# IMPROVEMENT LOCATION CERTIFICATE

Division of lots 4 and 5, Park Filing No. 1, in El Paso County, Colorado  
 a Commitment For Land Title Guarantee Company, No. 18, with an effective date of 05/30/19 P.M.

PROJECT No. 19100  
 MAY 30, 2019

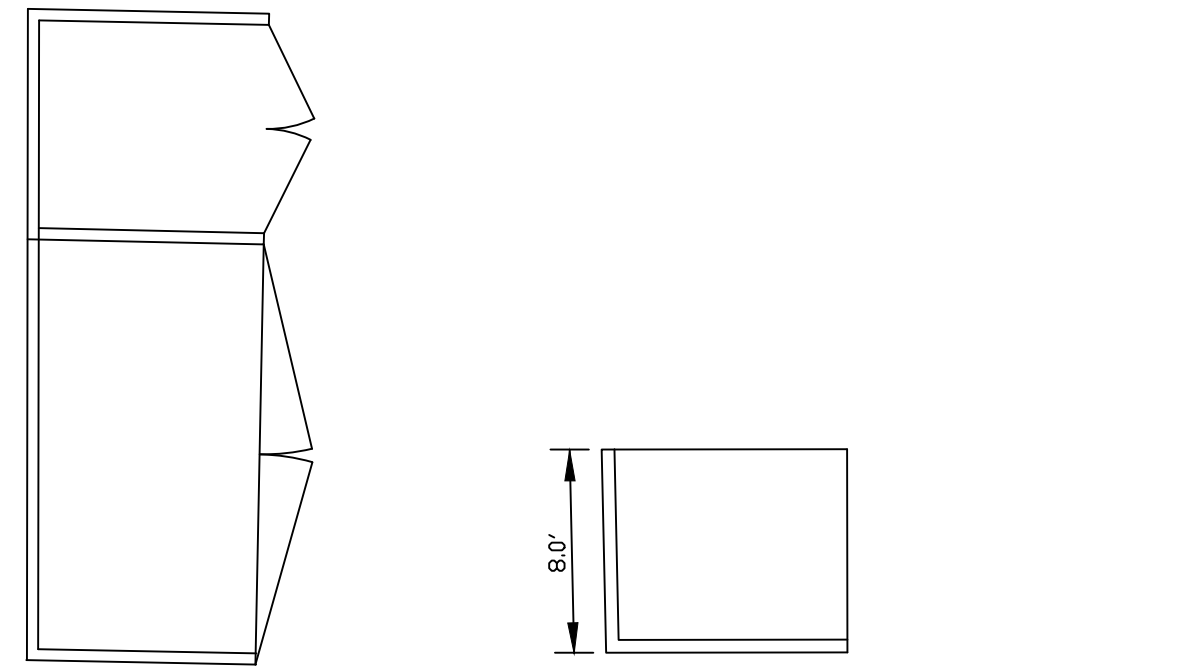
please read chapter 6 of the LDC and submit a new Site Development plan that shows the applicable information, the next review may have new comments and shall be considered a first review.

show the parking spaces, their width and length as well as an overall packing space count. show the ADA Spaces. show an ADA route from the spaces to the front door of the building. show a dumpster enclosure and show a construction detail with the materials, enclosures must be fully opaque and between 6 and 7 feet tall.

Bradley Rd.?

The following note should be added to all site development plans or non-residential site plans, as applicable, prior to PCD approval: The parties responsible for this plan have familiarized themselves with all current accessibility criteria and specifications and the proposed plan reflects all site elements required by the applicable ADA design standards and guidelines as published by the United States Department of Justice. Approval of this plan by El Paso County does not assure compliance with the ADA or any regulations or guidelines enacted or promulgated under or with respect to such laws.
